**LAND TO THE NORTH OF OLD WOKING ROAD AND EAST OF STATION APPROACH, WEST BYFLEET, WOKING, SURREY, KT14 6FD  
APPLICATION FOR A NON-MATERIAL AMENDMENT TO RESERVED MATTERS APPROVAL (PLAN/2022/0266)**

We enclose on behalf of our client, Retirement Villages Group Ltd (“the Applicant”), a Non-Material Amendment (“NMA”) application which seeks to amend the approved plans under condition 2 attached to the Reserved Matters Approval (PLAN/2022/0266) dated 09 May 2022.

This NMA application seeks to amend the approved plans set out under condition 2. Following a review of the technical design of the proposed development, it has become necessary to make a series of non-material design changes to the approved scheme.

WBF. -2013 REV D

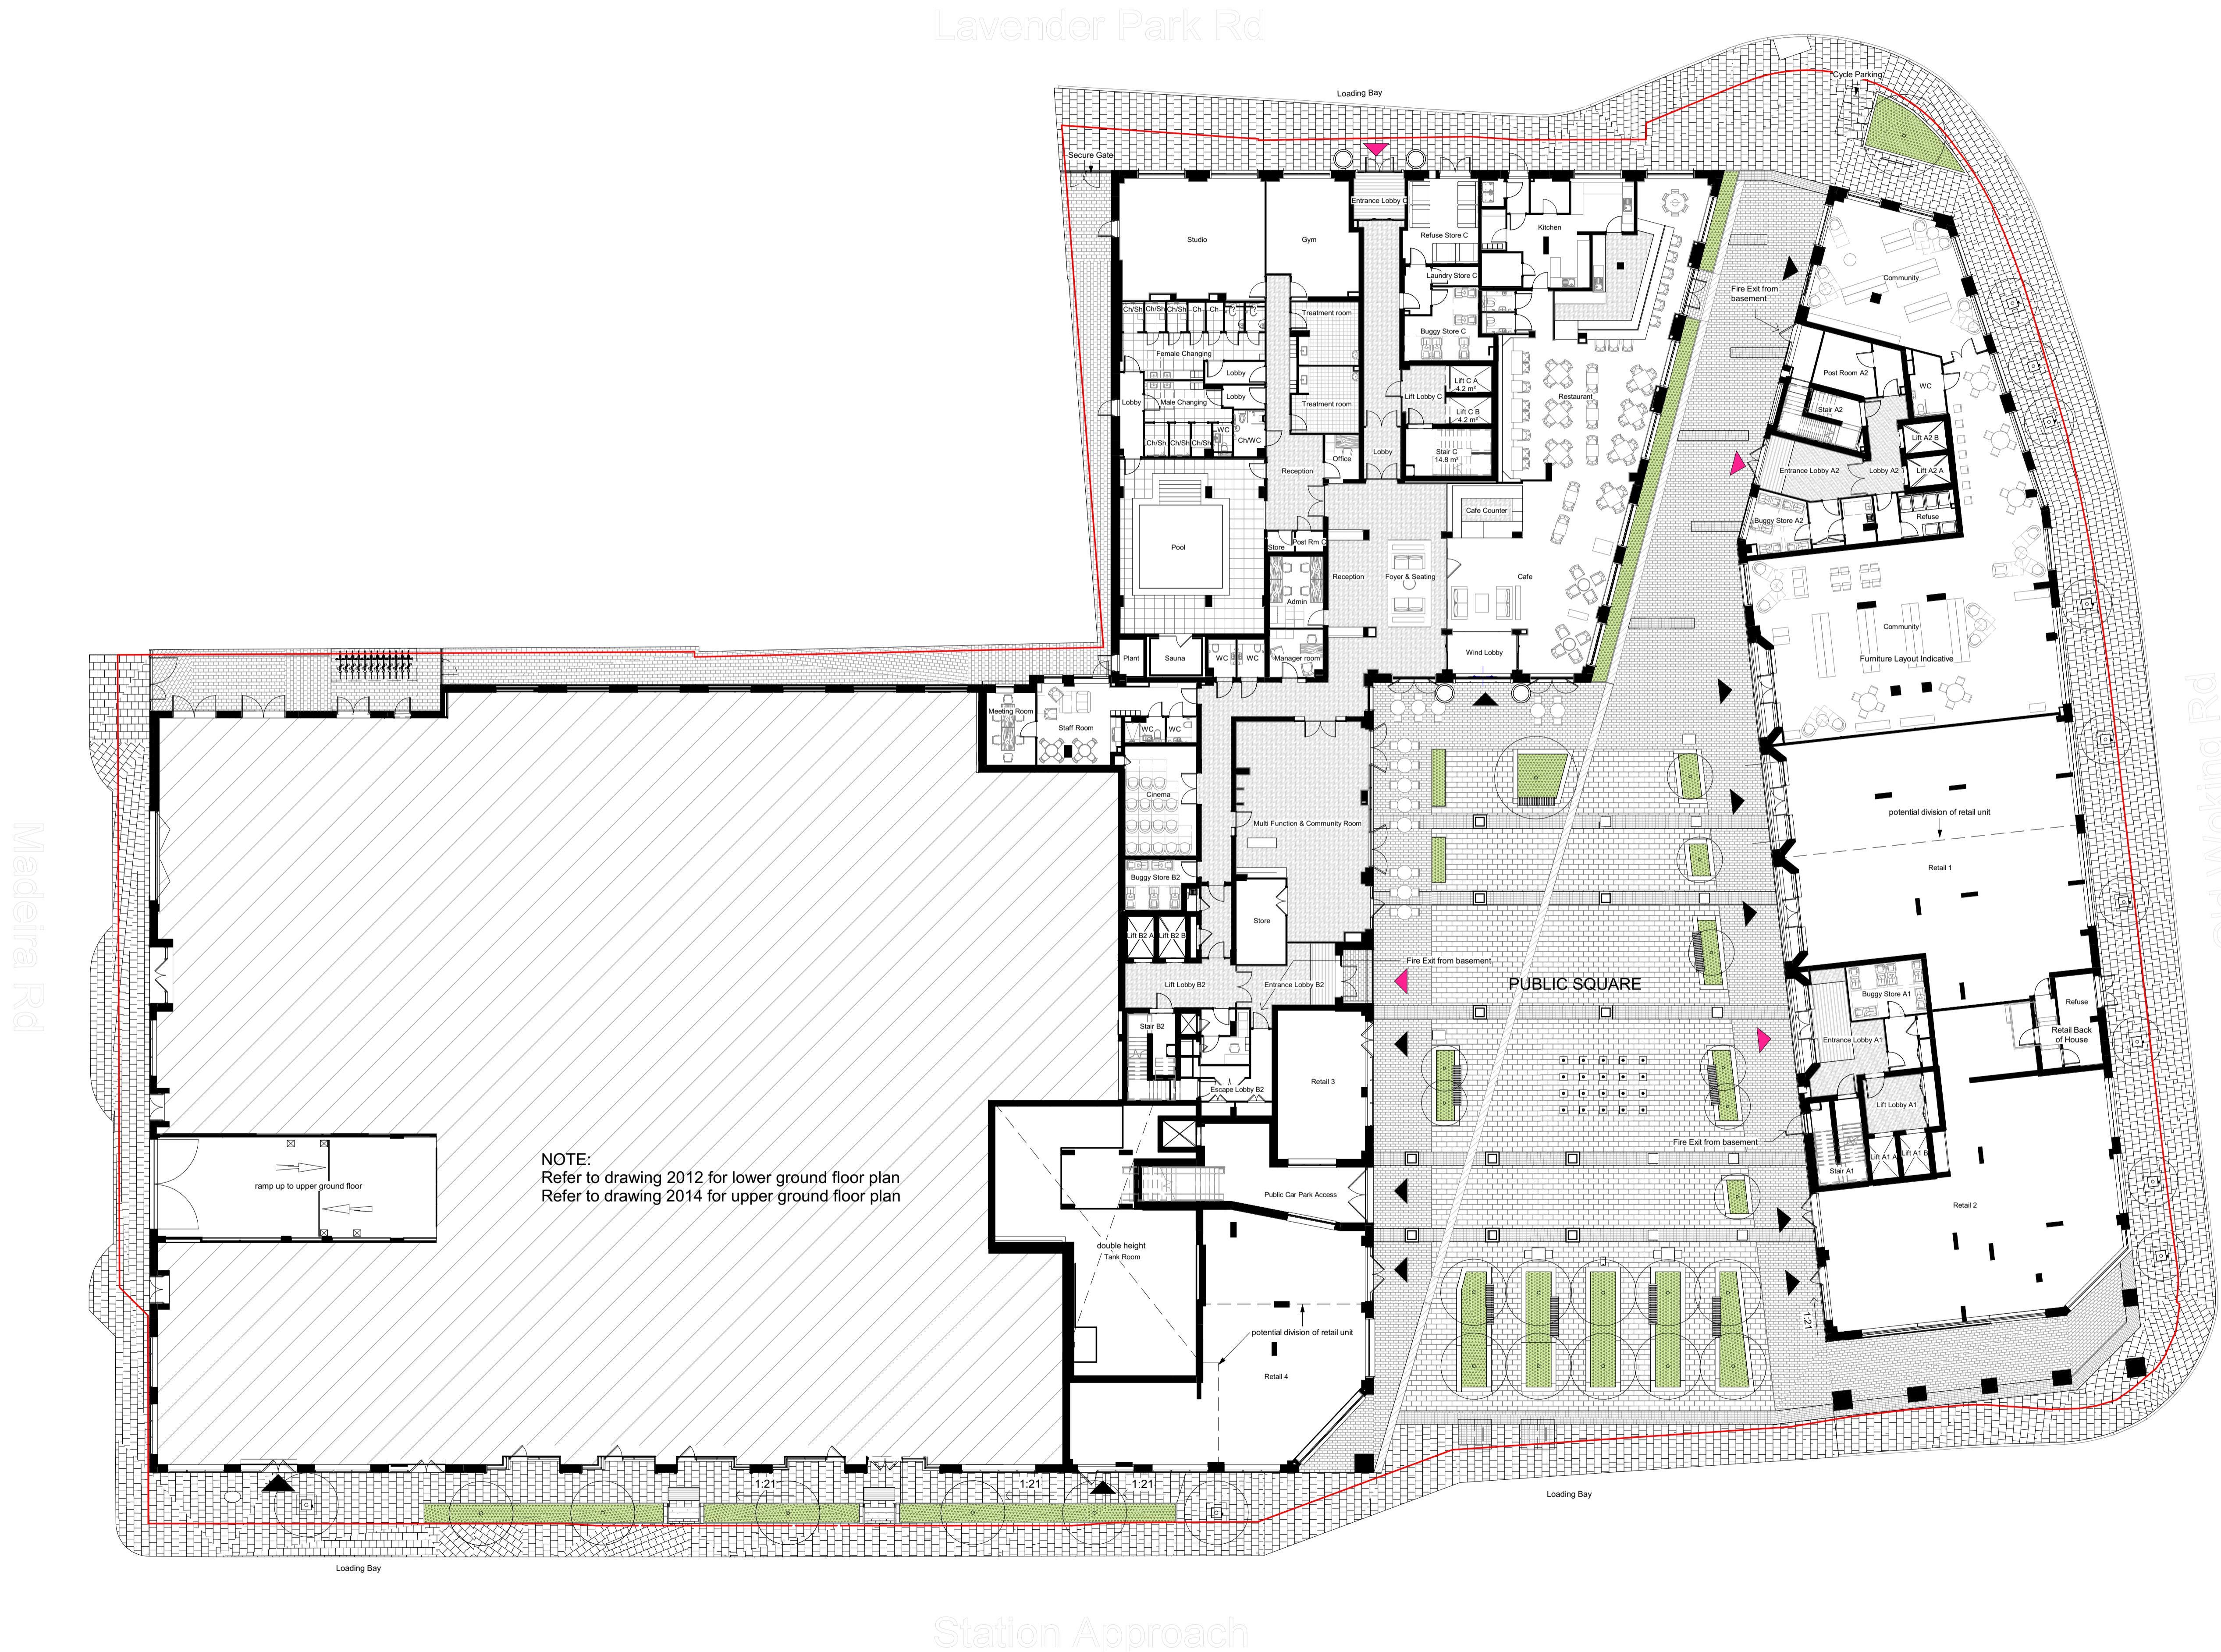
- A door has been added to Retail 2 for a fire escape.
- The entrance door to the community space has moved from Lavender Park Road to 'The Cut' in order to suit updated section 278 levels.
- One set of doors have been removed from Retail 3 to allow for adequate shopfront display and passive security. The previously approved plan allowed for 2 x double doors to a small retail unit.
- The doors to Retail 4 have been amended to outward opening for fire escape reasons.
- The public car park access gates have been amended to inward opening to allow for safe opening and to be neatly and tightly stowed away when open.

<b>WBF.</b>	<b>-2043</b>	<b>REV D</b>
<b>PLANNING</b>		
Drawn SB	Checked CJP	Date 16 DEC 2020 Scale @ A1 As indicated

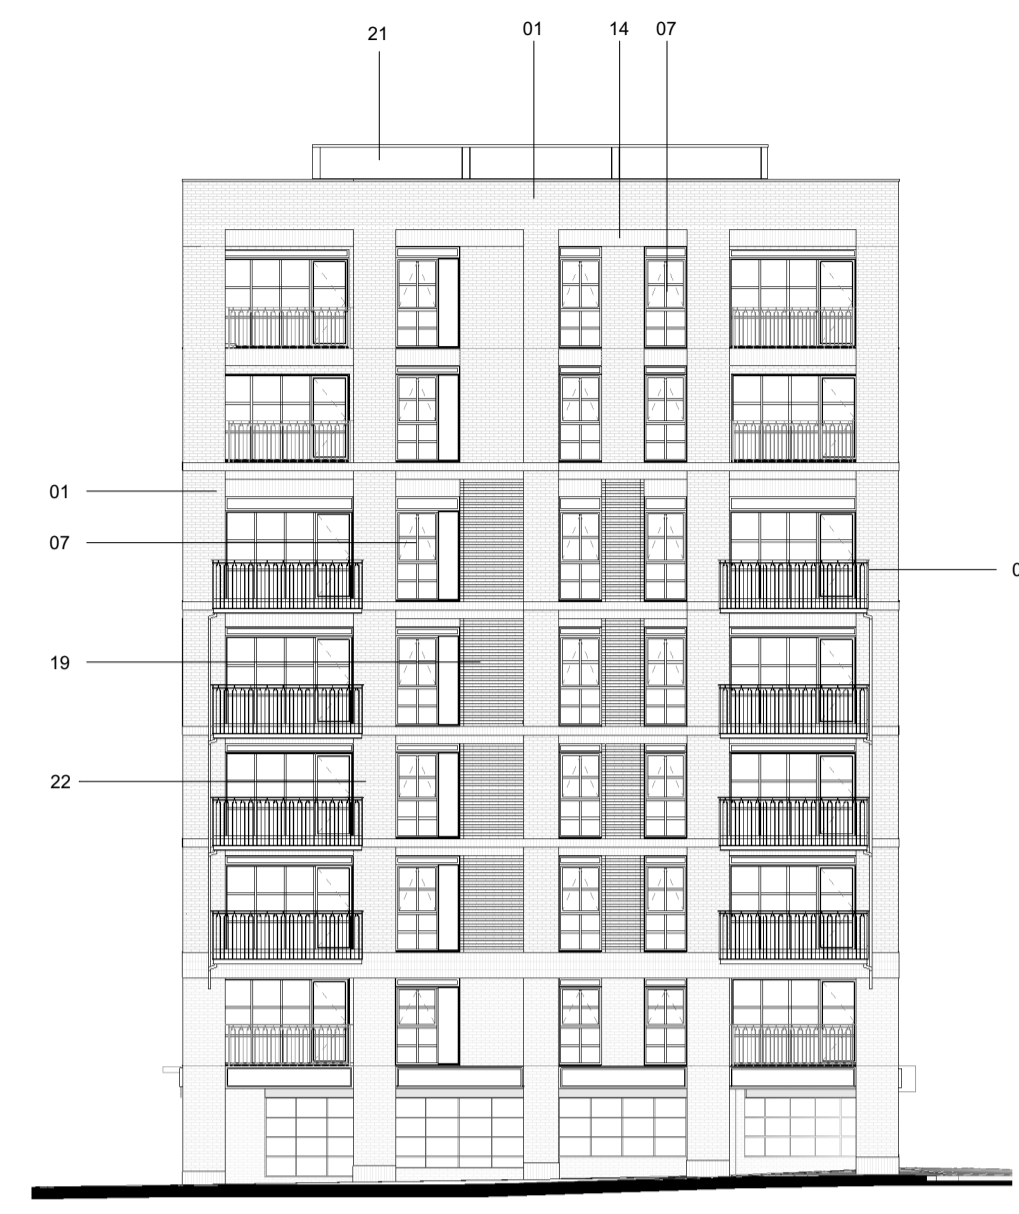
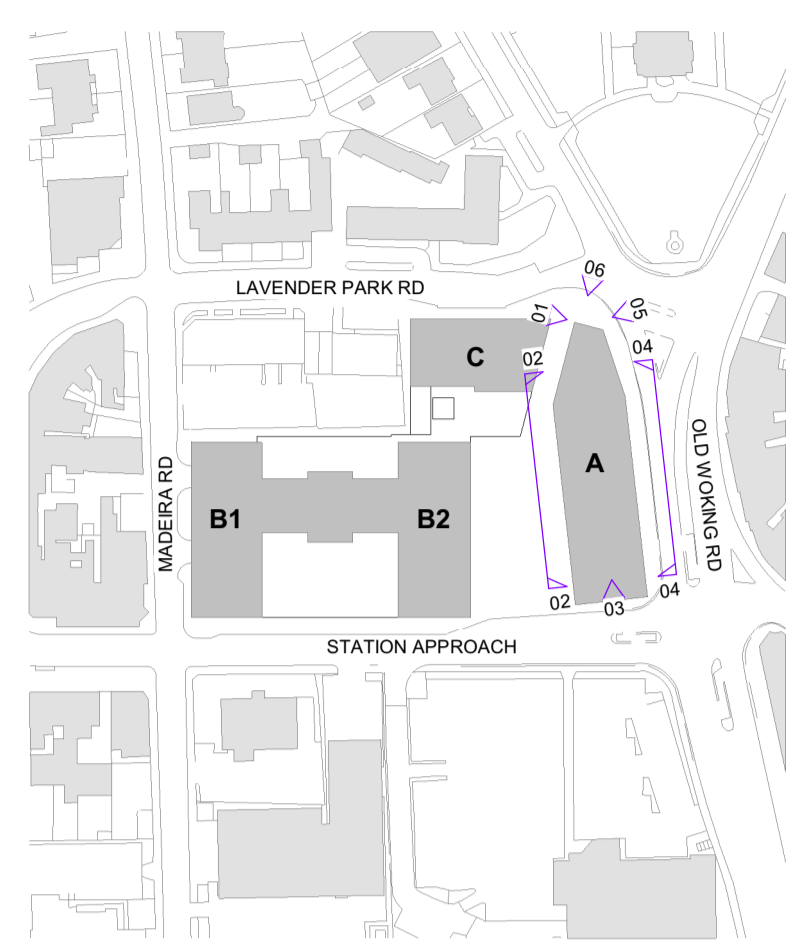
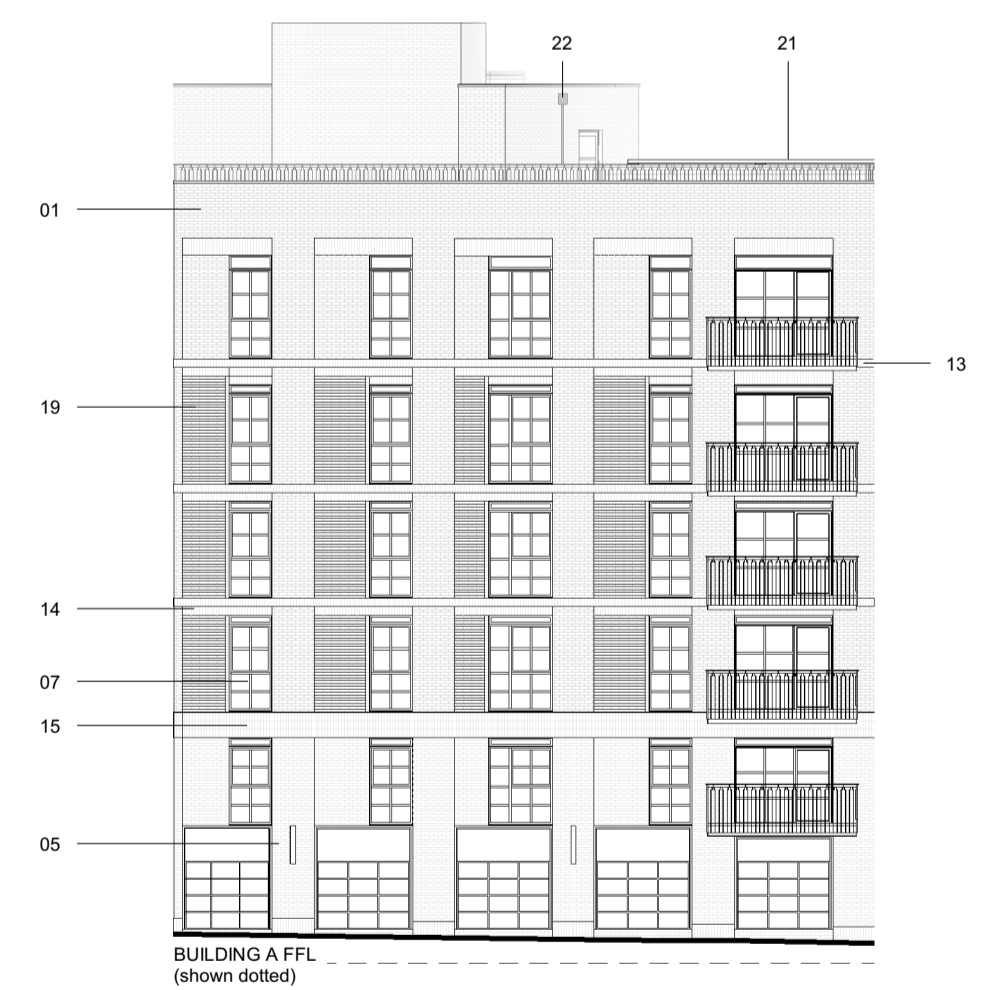
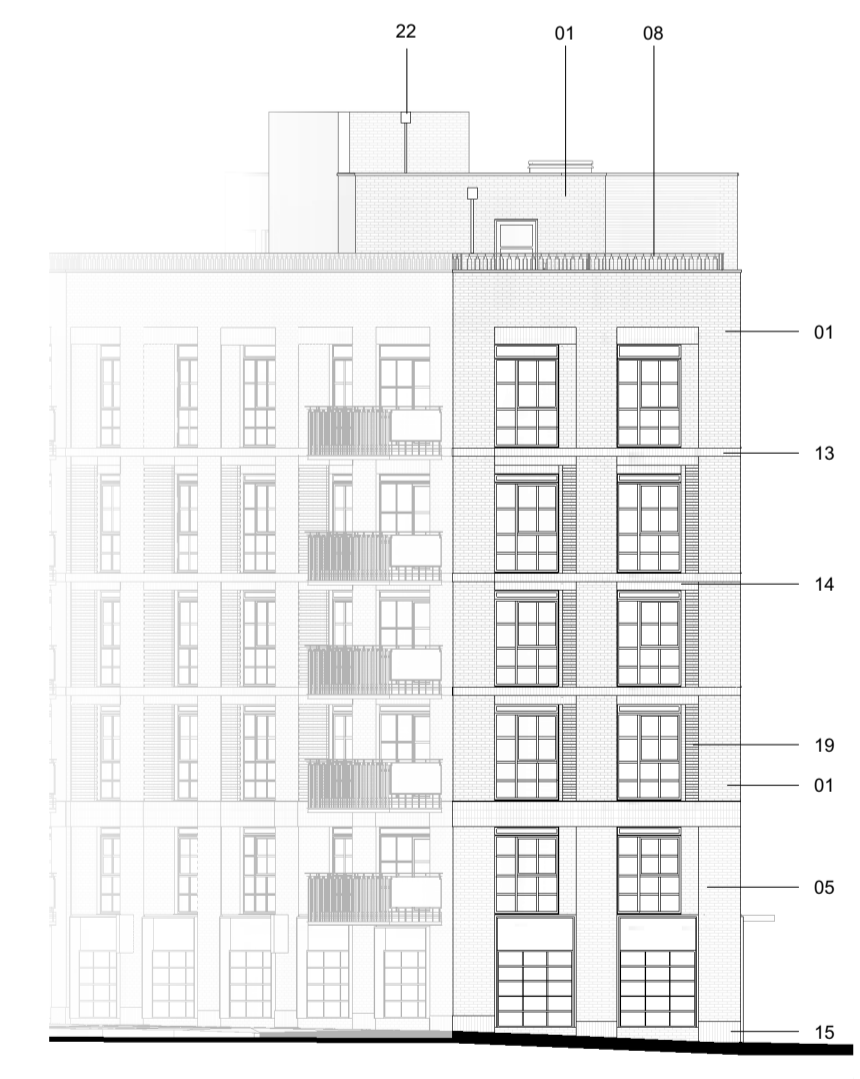
- Elevation 01 – Doors to community space have been added to suit updated section 278 levels. In addition, louvre above ground floor escape door has been added to allow mechanical extract from basement. Louvre also has been added above the shopfront glazing to allow for mechanical extract.
- Elevation 02 - Louvre added above the ground floor escape door to allow for mechanical extract. Window added at first floor level above covered route to provide window to lounge and to match similar apartments on floors above.
- Elevation 04 – Louvres added to the above ground floor shopfront glazing to allow for mechanical extract.
- Elevation 06 – Door to community space facing Lavender Park Road moved to 'The Cut' to suit updated section 278 levels.
